April 19, 2019

We welcome the opportunity to submit a proposal for obtaining a special use permit for horse training, horse riding lessons, and boarding horses at 14650 Eastonville Rd Elbert, CO 80106. We understand the need for a special use permit, and we are willing to move as quickly as needed to ensure a smooth and easy process and believe we are well suited to do so. This letter summarizes our proposal.

CARLSON Subdivision
LEE WILWERDING
14650 EASTONVILLE RD.
ELBERT, Co. 80106

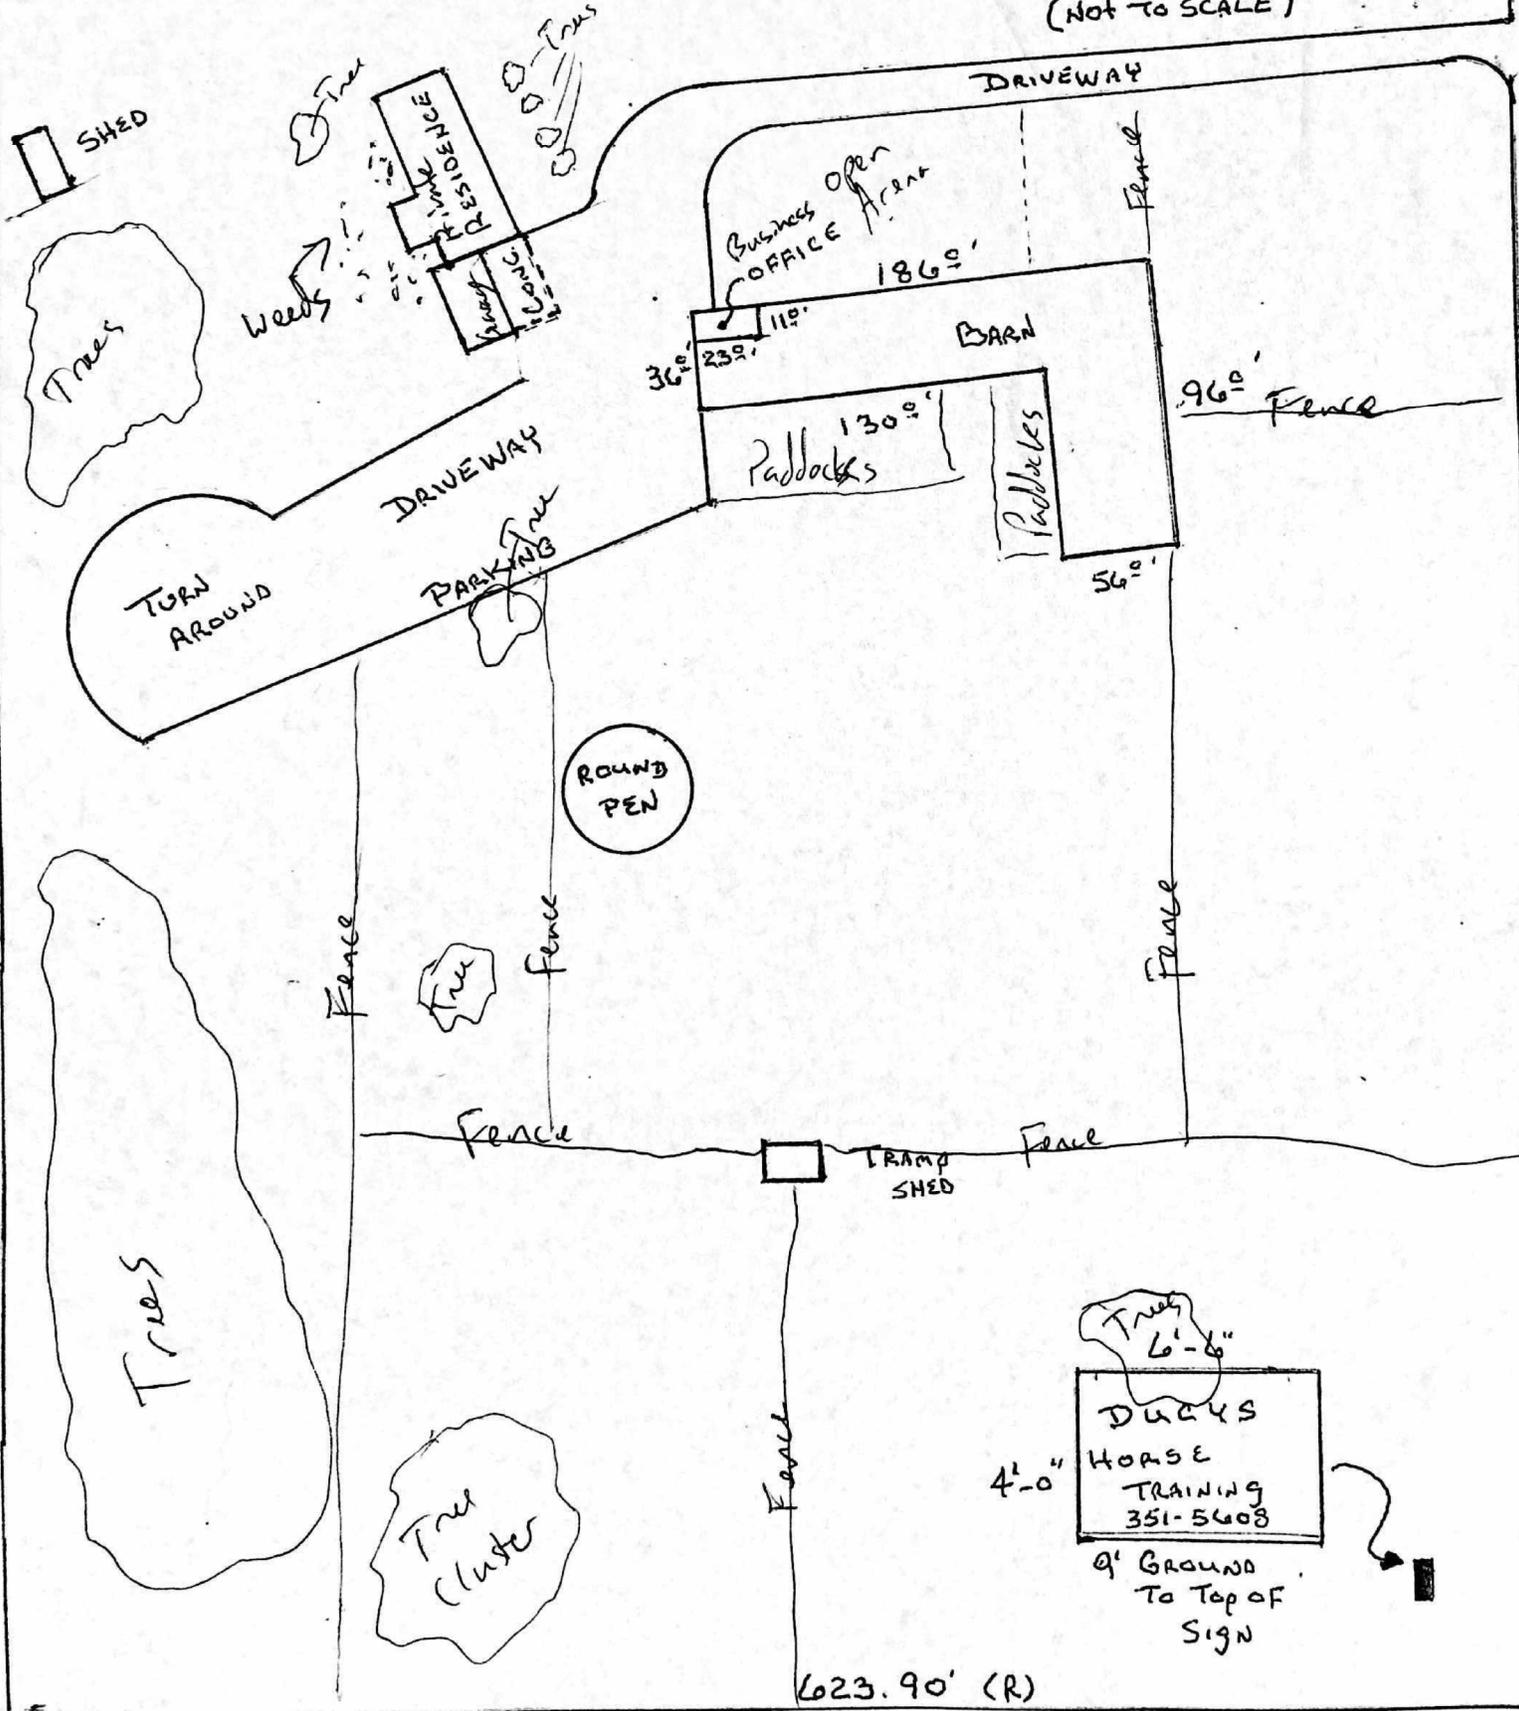
Landscaping is required per the Land Development Code for all non-residential uses. Existing landscape can be shown on a plan and credited toward landscape requirements. The Planning Director has the authority to approve landscaping that does not meet the specific requirements of LDC Section 6.2.2 provided that the proposed landscaping meets the purpose of that section and/or promotes the concepts from the Landscape and Water Conservation Manual and provides an equivalent benefit to the community and the environment. If you want to request alternative landscaping, you need to detail that request in the Letter of Intent and provide a landscape plan with next submittal.
